Heckington Fen Solar Park

EN010123

Schedule of Changes to the draft Development Consent Order

Document Reference: ExA.SCHDCO-D3.V1

DATE	SCALE	SHEET	REVISION
24/01/2023	1:2,500@A1	5	.

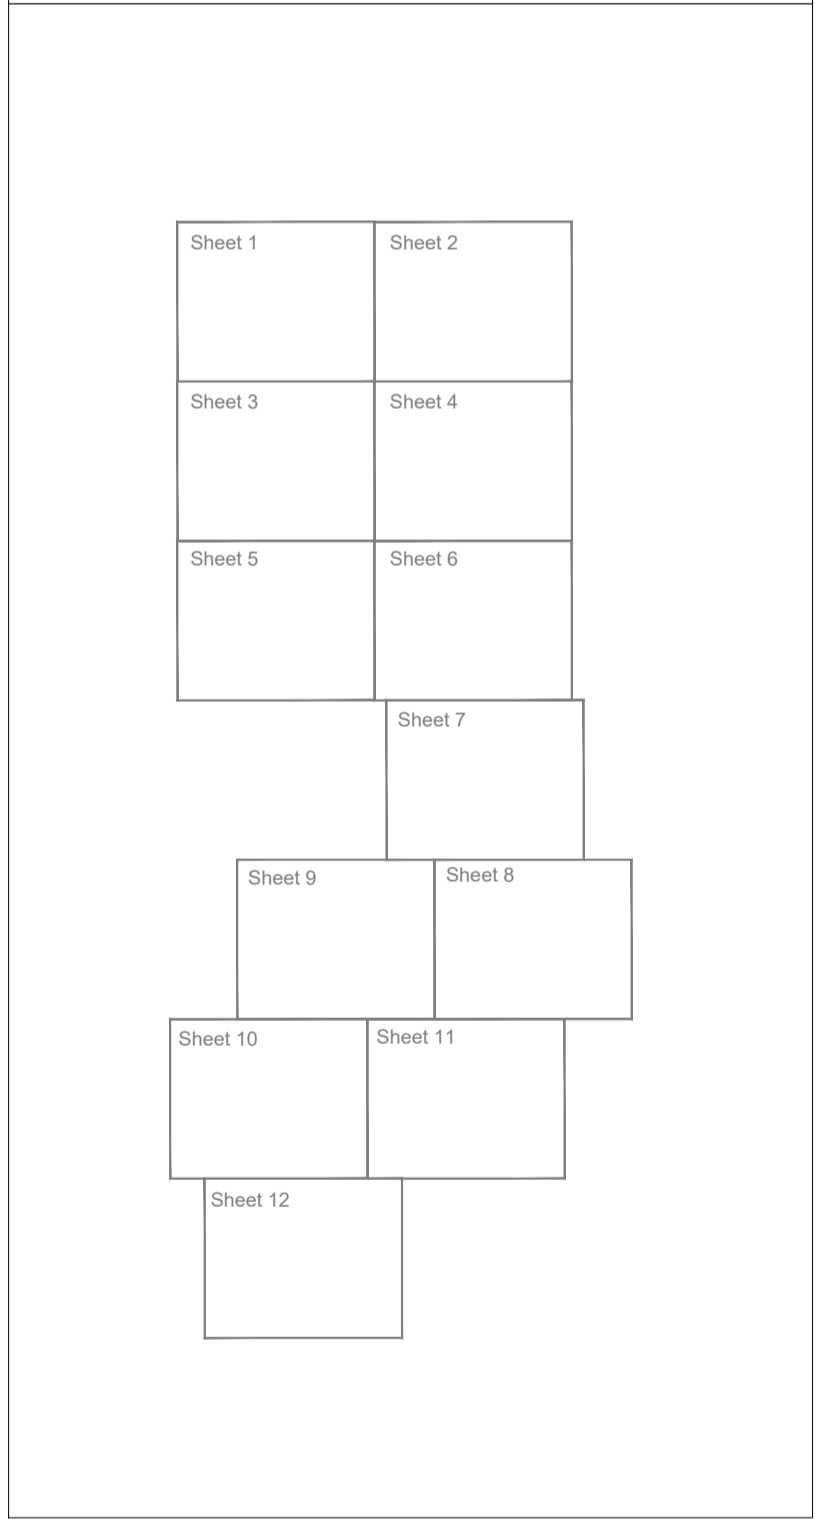
Ref	DCO Ref	Consultee (if relevant)	Comments from consultee or rationale for the change	Change Made	DCO Version
1.	Schedule 7	The Planning Inspectorate (PINS)	As part of their section 55 advice, PINS raised a question on the colouring on the Street and Access Plan (document reference 2.7). As a result, the Applicant has updated the description in the DCO for clarity.	<p>Part 1 has been updated as follows:</p> <p><i>"The provision of a permanent means of access to the authorised development from the north side of the A17, at point EP/B and the area hatched coloured pink on sheet 5 of the streets and access plan"</i></p> <p>Part 2 has been updated to refer to the area coloured purple rather than hatched blue as follows:</p> <p><i>"The provision of a temporary means of access to the authorised development from the north side of [the A17], at point [EP/A] and the area hatched-blue coloured purple on sheet [5] of the streets and access plan"</i></p>	2
